# CITY OF ALBUQUERQUE

March 31, 2021

RE: **Lot 2 Block 1 Unit 22 SAD 228 Volcano Cliffs Subd.  
8005 Alto Rey Ct. NW  
Grading and Drainage Plan  
Engineers Stamp Date 10/29/2020 (D10D003N2)  
Pad Certification Date: 3/11/2021**

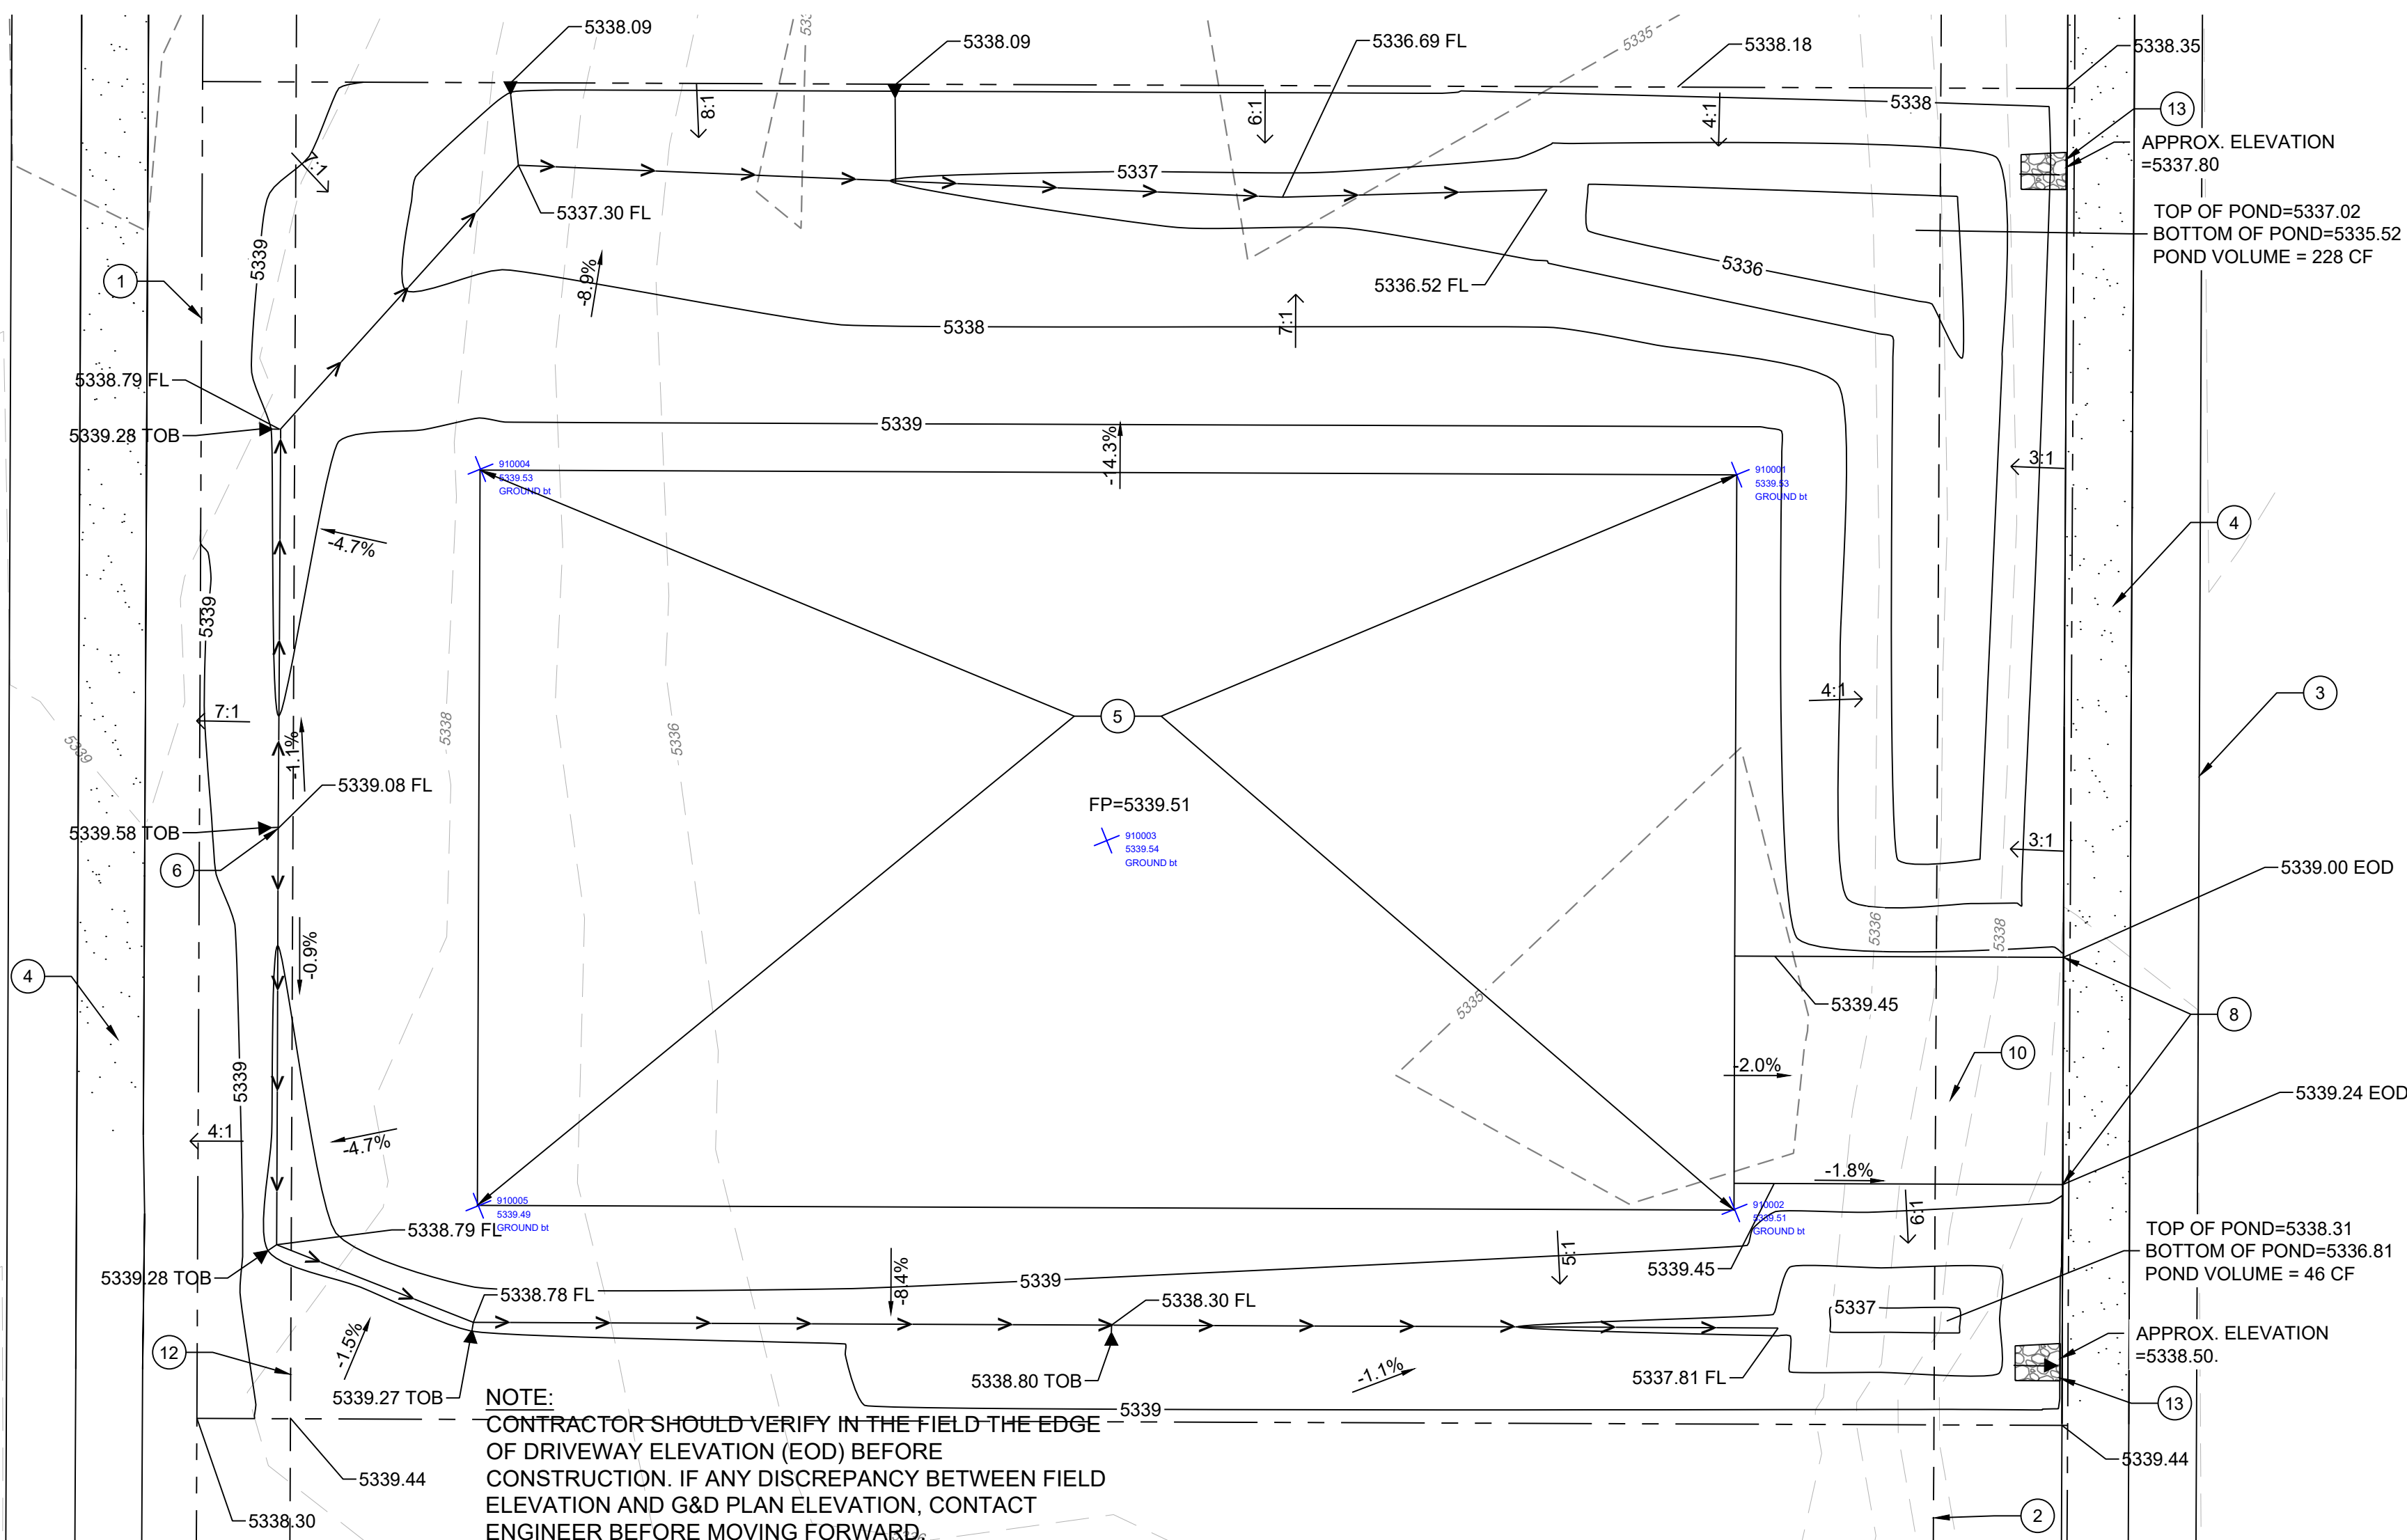
- Remove all dirt from the street. Dirt is not allowed to use as a ramp for going over the curb, only lumber or crusher fines are acceptable.
- Remove the dirt in the channel, it is blocking the flow from Alto Rey Ct. to Agua Fria Ct.

Reiterate to the Owner/Contractor that a separate permit for a garden/retaining wall must be obtained with the approved G&D plan and Pad Certification. **Also, if a swimming pool is to be placed the grading and drainage plan will change and will need to be resubmitted.**
